Application Ref:	2025/0356			 Ribble Valley Borough Council www.ribblevalley.gov.uk				
Date Inspected:	19/06/2025	Site Notice:	29/06/2025					
Officer:	EP							
DELEGATED ITEM FILE REPORT:					APPROVAL

Development Description:	Removal of three single storey extensions, erection of a single storey front entrance extension, rear two storey extension and fenestration amendments. Retrospective submission relating to the formation of front parking area.
Site Address/Location:	4-5 Brookside, Holden Lane, Bolton by Bowland.

Drawing Title
Proposed Site Plan
And Retaining Wall Elevations

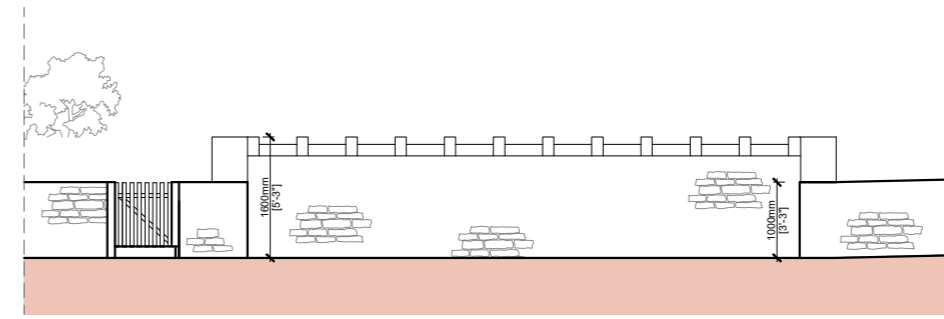
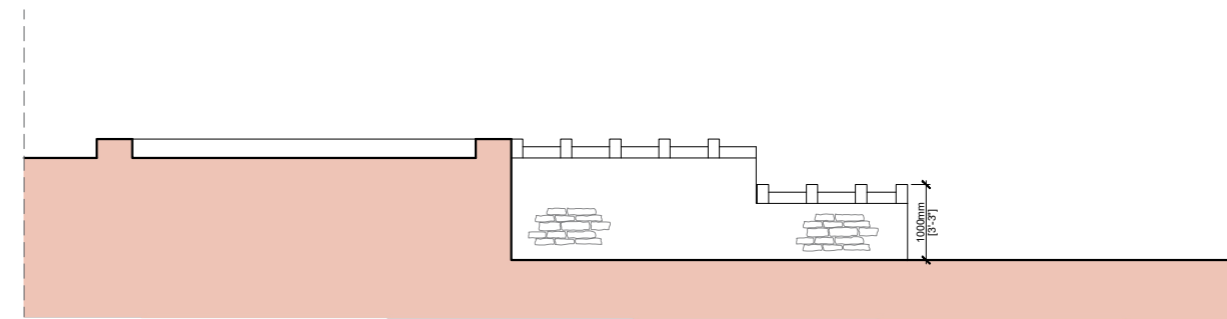
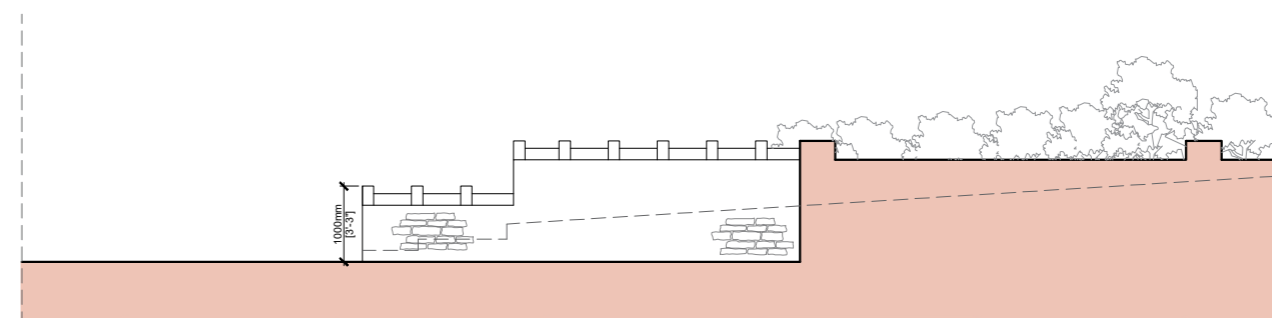
- The height of the retaining walls between the carriage ways will be a maximum height of 1m to allow suitable visibility and manoeuvring.
- Surface of the parking area should be bound and porous.

Subsequently, amended plans were submitted addresses the above. There are therefore no concerns from a highway safety perspective.

Drawing Title
Proposed Floor Plans And Elevations

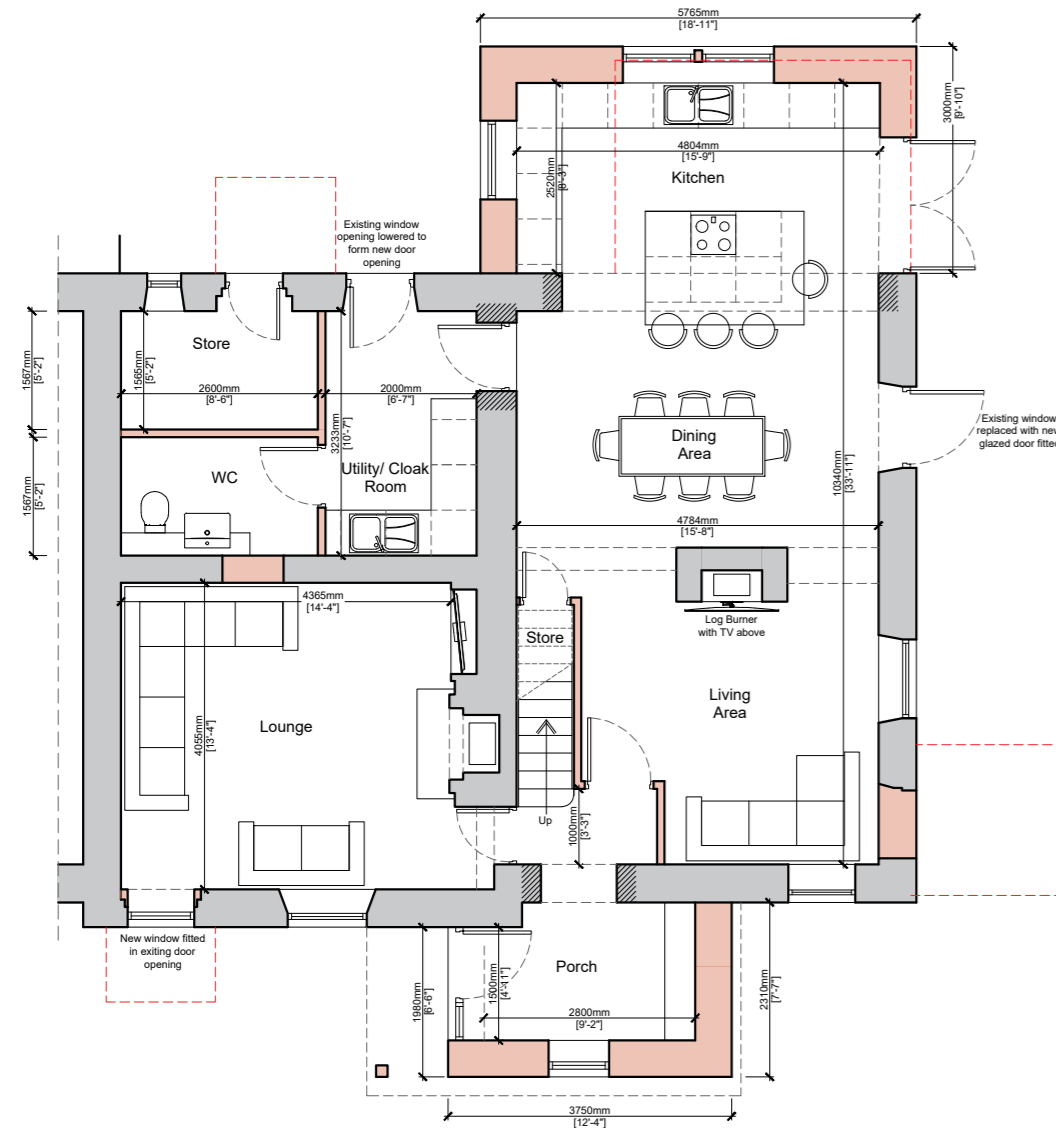
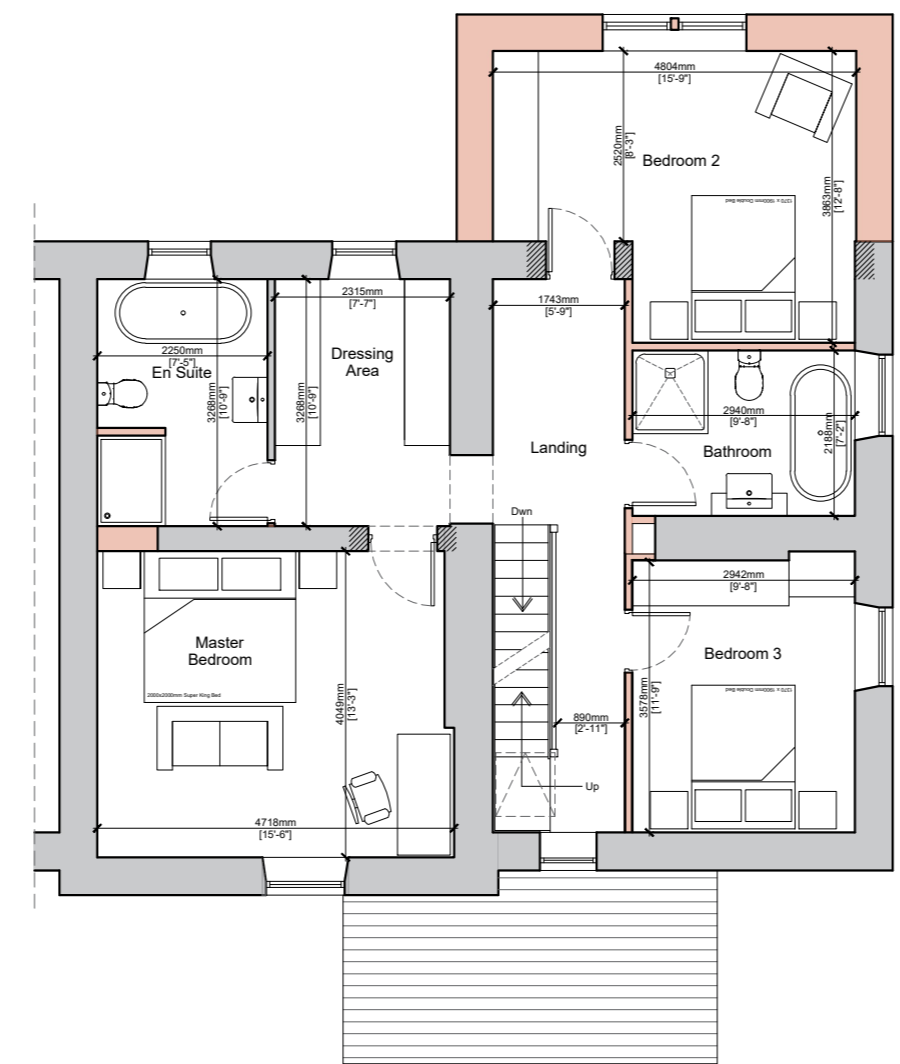
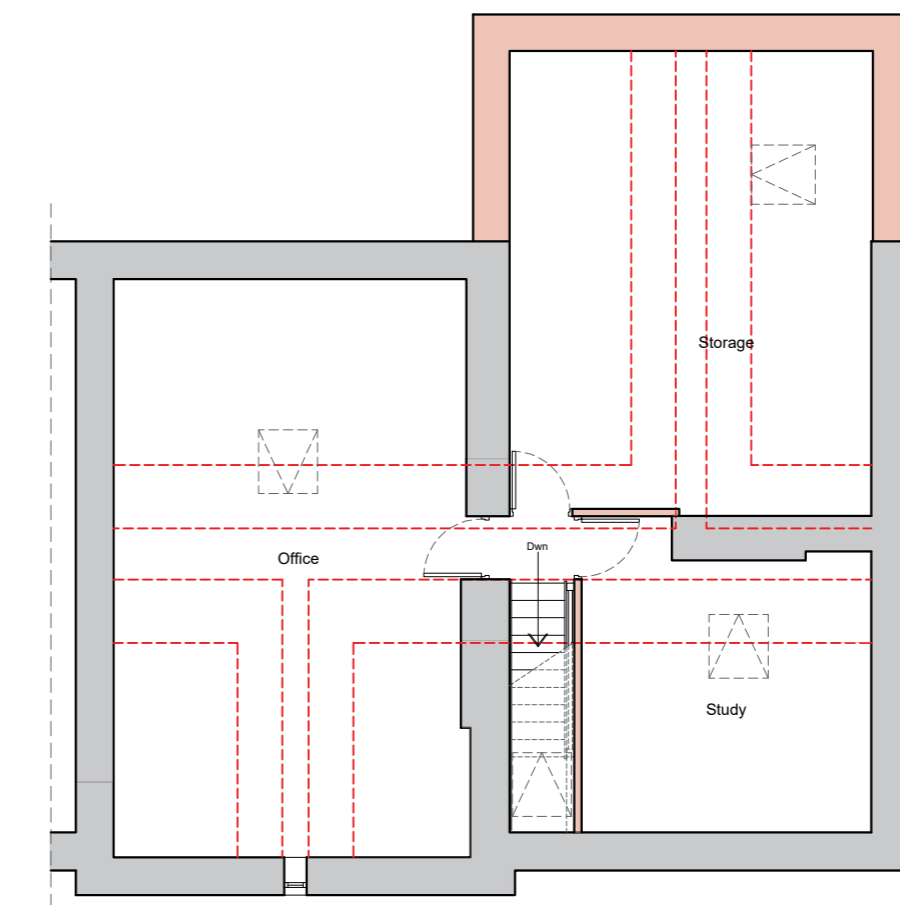
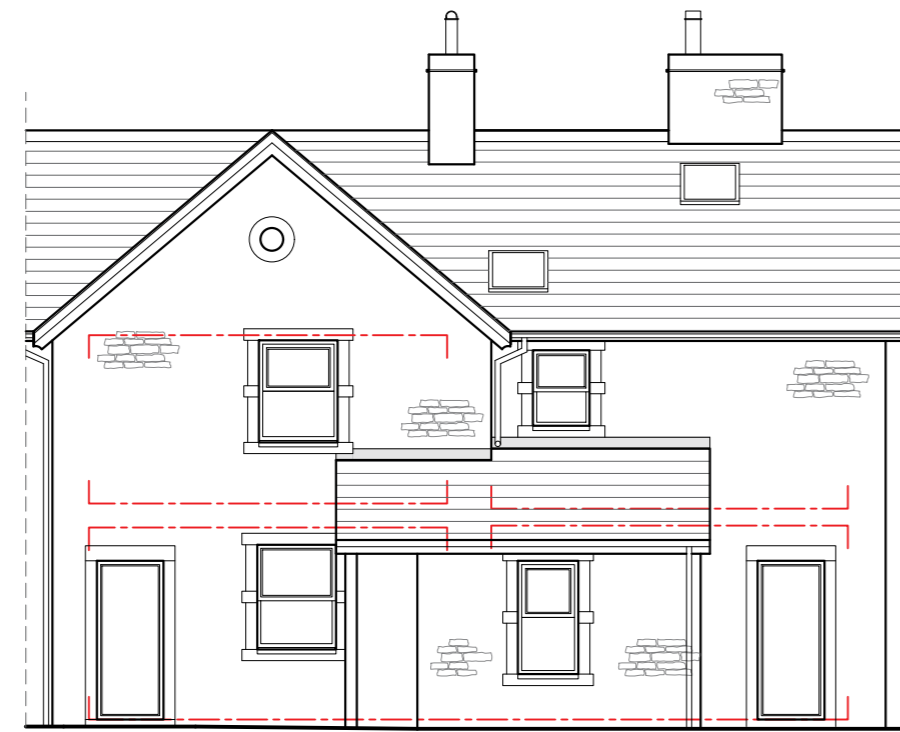
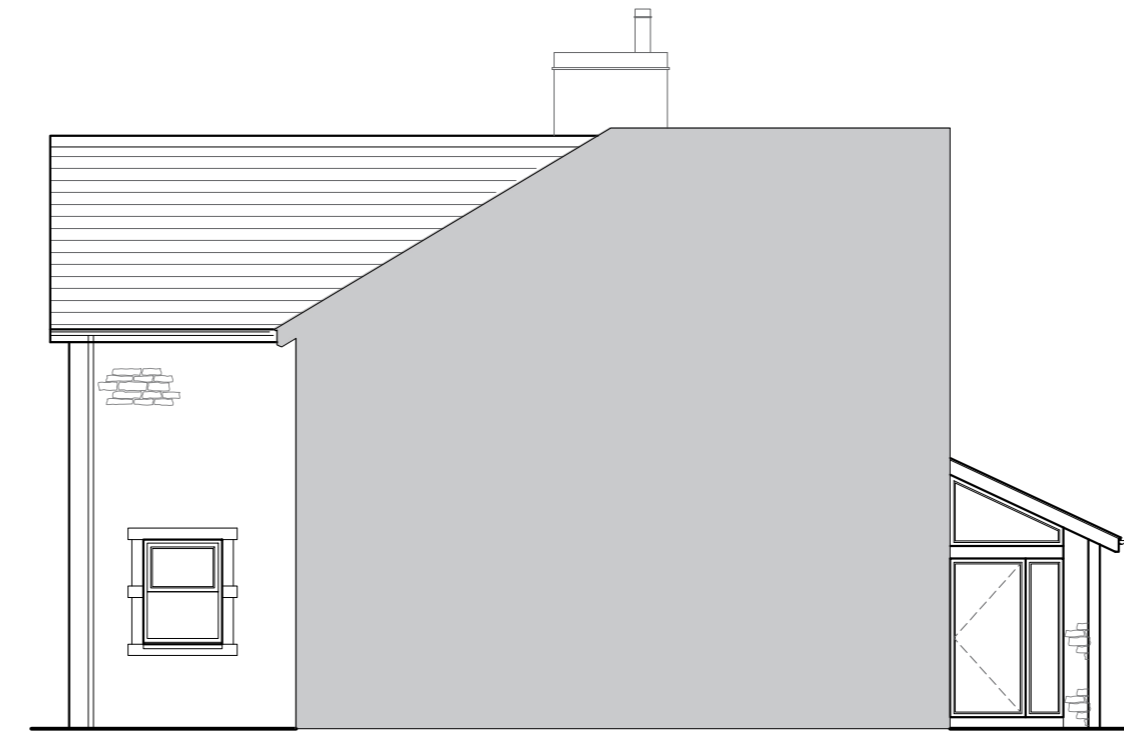
The rear elevations of the Brookside properties face Tinklers Lane. There are varying types of rear extension along this row, with no defined sense of uniformity. As such, the proposed rear extension will not read as out of character. The proposed scale of the rear extension is modest in relation to the host dwelling, measuring 5.7m by 3m with an eaves and ridge height of 5.2m and 7.76m respectively. This will not result in the creation of an overbearing or disproportionate addition to the dwelling and is therefore acceptable in respect to overall scale and footprint, being relative to the scale of the main dwelling.

The proposed porch extension is similarly modest in footprint, measuring 3.7m by 2.3m. Due to the modest nature of the porch extension it will not dominate the principal elevation or detract from the character of the dwelling itself. There is also various fenestration alterations proposed to the principal elevation, including the introduction of window openings on a currently blank elevation. The existing blank elevation is considered to lack architectural interest, and the introduction of window openings will improve the visual appearance of the dwelling. Similar to the rear, there is no defined sense of uniformity across the principal elevations on Brookside. It is therefore not considered that the proposed works will read as out of character within the street scene.

In respect to materials the proposed extensions will be constructed using natural stone to the elevations, with stone roof tiles and timber framed windows all to match the existing dwelling. The proposed development will therefore integrate sufficiently into the wider area.

Drawing Title
Proposed Site Plan
And Retaining Wall Elevations

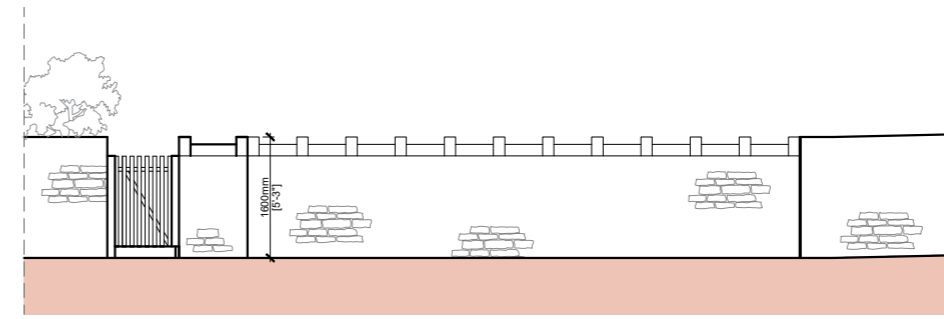
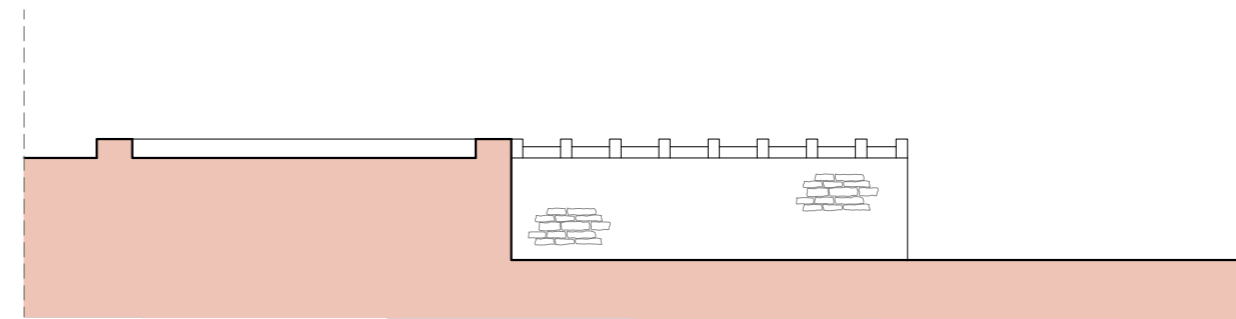
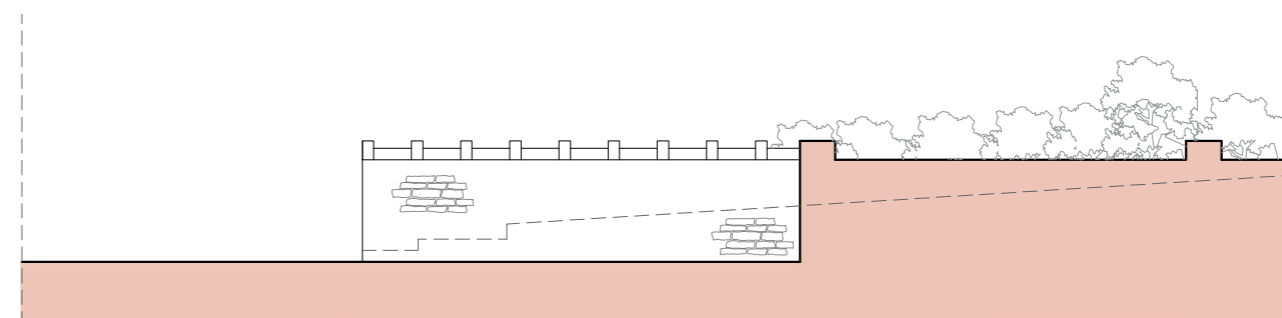
CONSULTATIONS:	Highways/Water Authority/Other Bodies
LCC Highways:	No objection subject to receipt of amended plans relating to visibility splays and surface materials for parking area.

LCC Highways were consulted in relation to the proposal and raised no objections subject to two matters being addressed as follows
